Memorandum

To:	Elizabeth Thompson	Date:	August 18, 2022
From:	April Ng		
Project:	Butenwieser/Wiley Residence 6838 96 th Ave SE Mercer Island, WA 98040 King County APN 302405-9010	File No:	CAO21-007 SHL21-042 SEP21-027
Subject:	CAO 21-007 SUB 2 Resubmittal

This memorandum responds to comments received from Michele Lorilla, Geotechnical Peer Reviewer dated June 1, 2022 for Mercer Island: Cascade. File Number: CAO 21-007, SUB 2.

Support Name	Color	Out-Of-Plane Spacing (ft)	Pile Shear Strength (lbs)
Soldier Pile - Wall 3	■	8	180000

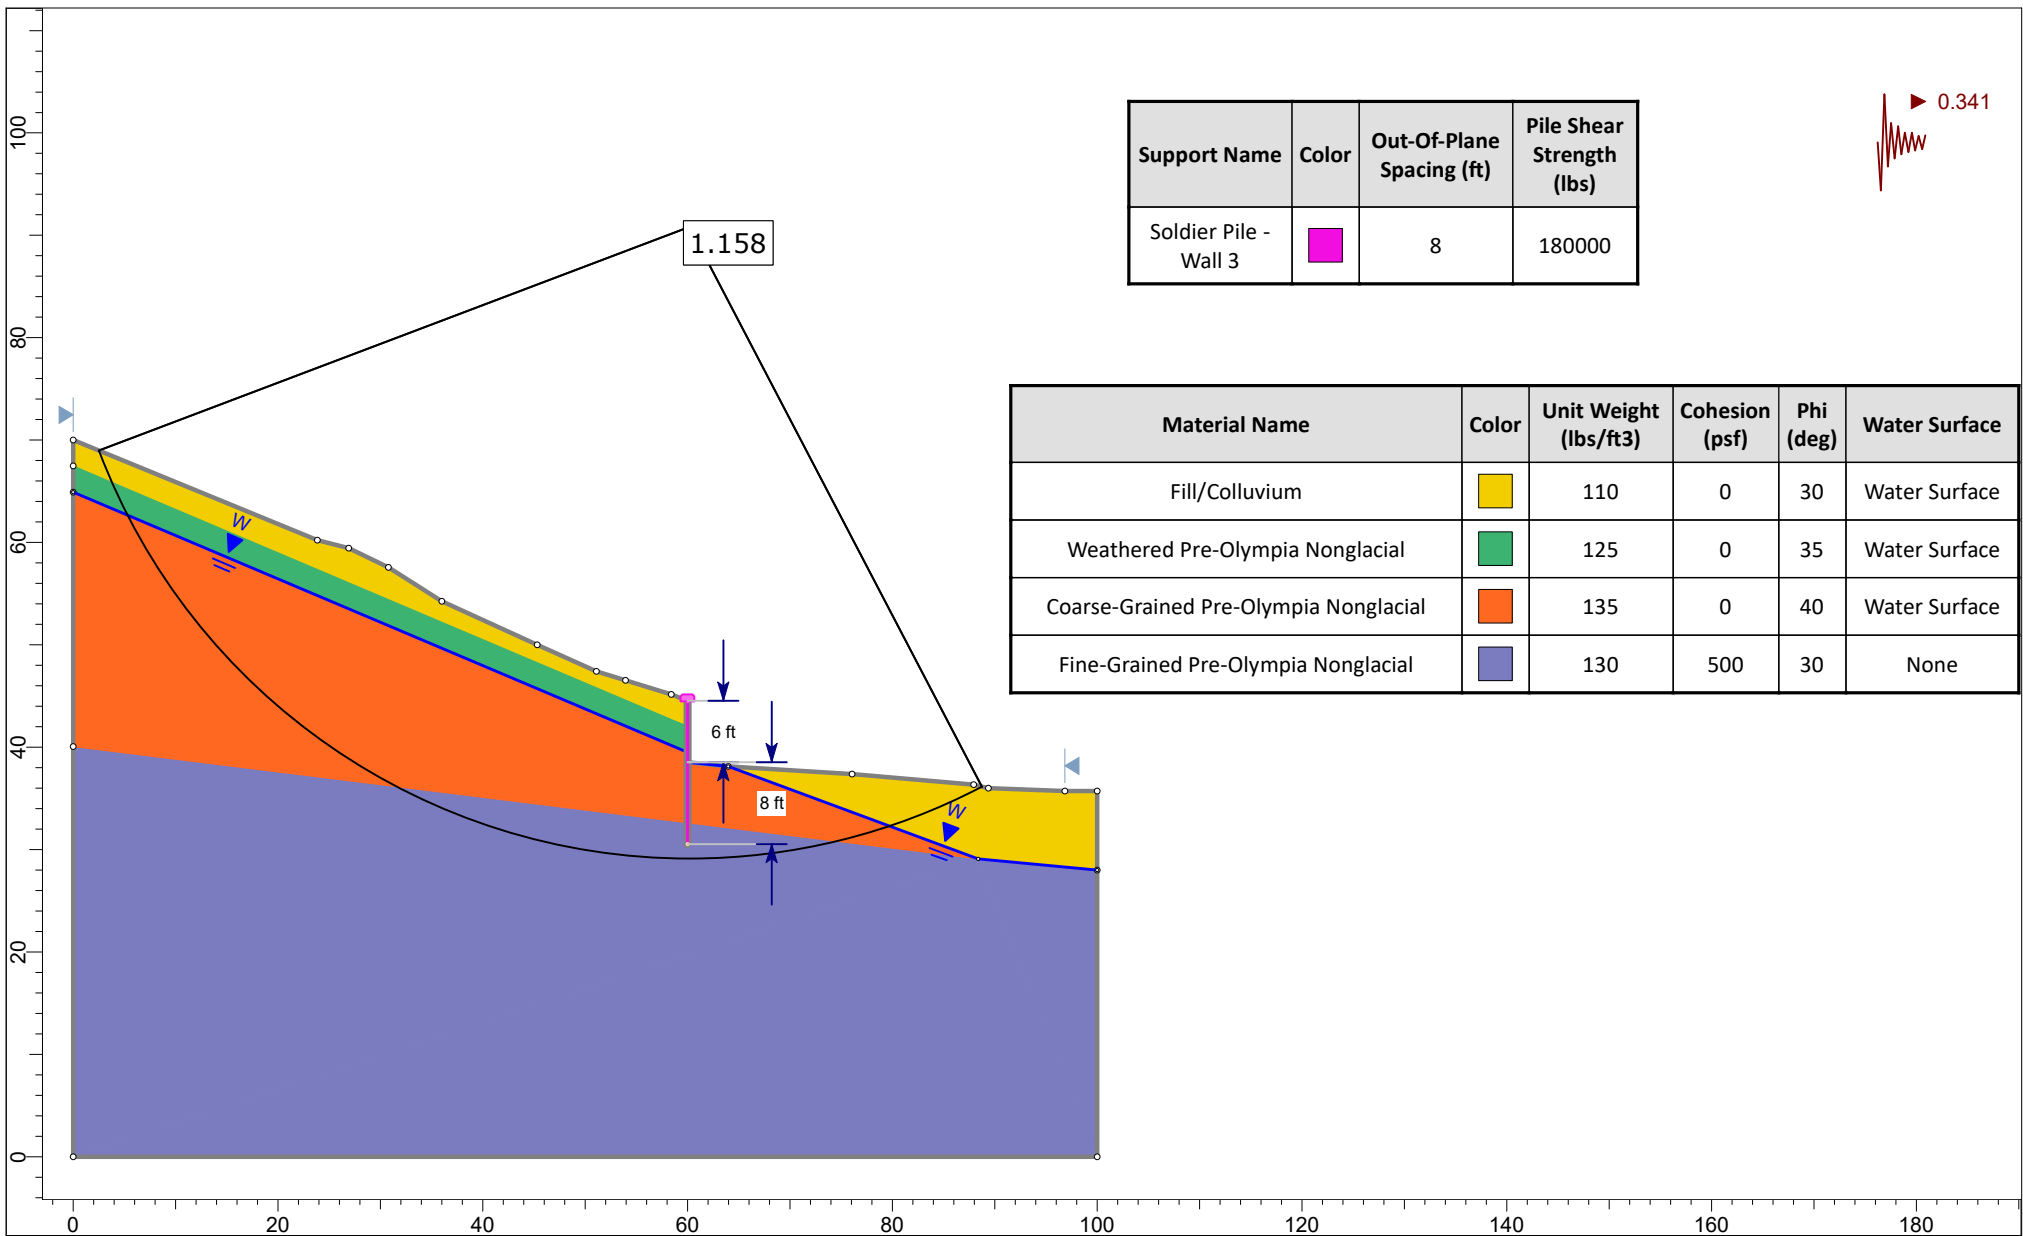
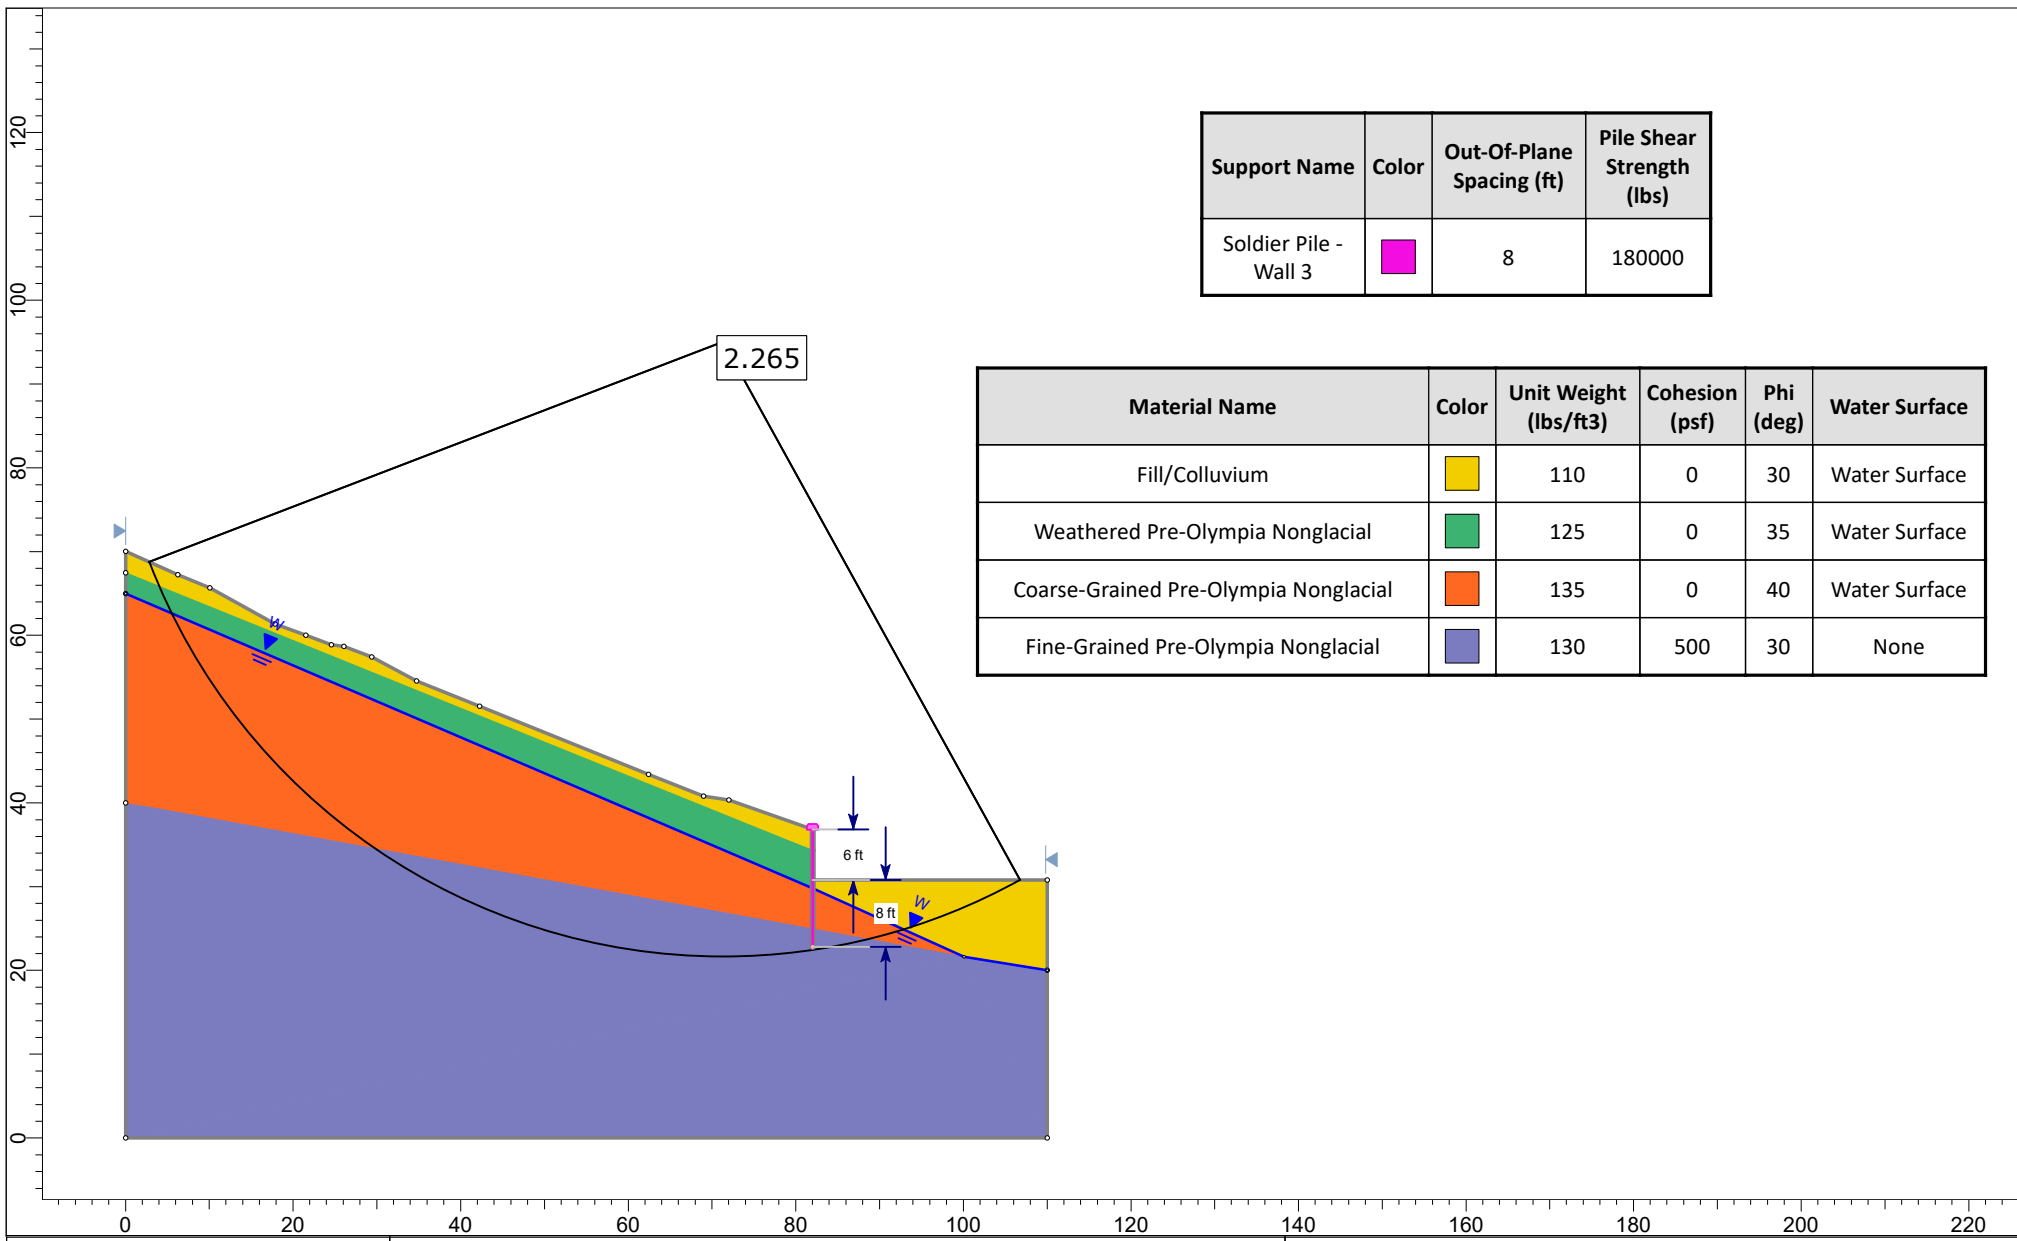
Geotechnical Engineering Peer Review		
<i>Comment</i>	<i>Response</i>	<i>Document Ref.</i>
<p>"The geotechnical addendum addressed many of our review comments from the SUB1 review phase. The outstanding item remains the issue of catchment capacity and design of Aspect designated Wall 3. According to the geotechnical report addendum... .. the stratigraphy used in the slope stability cross-sections was not determined by specific borings or information at those specific cross-section locations... .. We recommend that the geotechnical engineer resolve the lack of subsurface information, revise cross-sections using the results from explorations located on the slope, revise slope stability analyses and catchment calculations.</p>	<p>Aspect advanced a series of supplemental hand auger explorations on the slope to provide additional information regarding the thickness of the colluvium layer in cross-sections C-C', D-D', and E-E'. The supplemental exploration logs are included as an appendix to the revised geotechnical addendum. We revised the slope stability analyses and catchment calculations appropriately and included updated output results as appendices to the revised geotechnical addendum.</p>	<p>Geotechnical Addendum Dated 4/26/2022 (Revised August 16, 2022)</p> <p>Appendix A City Comment Response Letter No. 2 (July 20, 2022)</p>
